Our Ref: WA/90/18/HH
Your Ref:

Town & Country Planning Act 1990 (as amended)
Town & country Planning (Development Management Procedure) (England) Order 2015
Application for Planning Permission for Works or Extension to a Dwelling

Development Retrospective application for rear single storey extension.

Location Chillerton Down Yapton Lane Walberton

sheet 2 a of 3

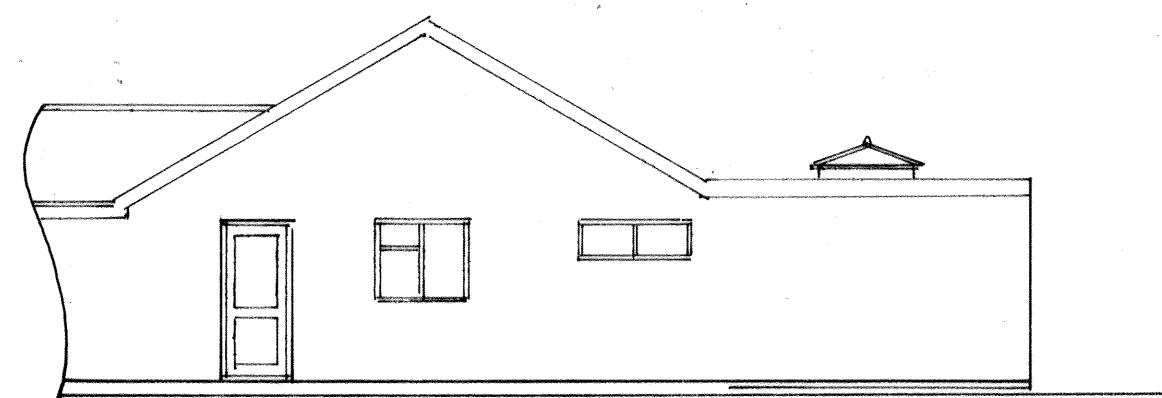
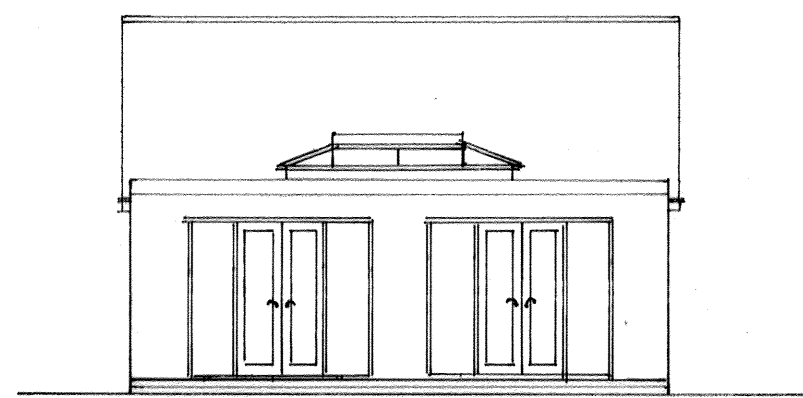
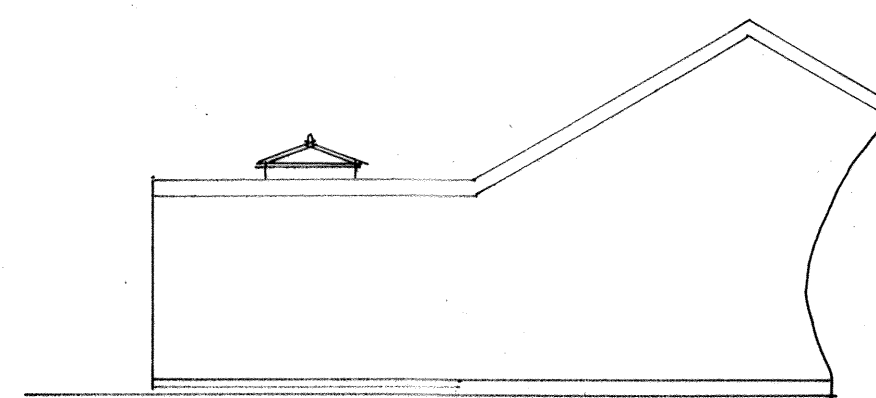
Elevations

The proposed elevations do not measure correctly to the stated scale of 1:50.
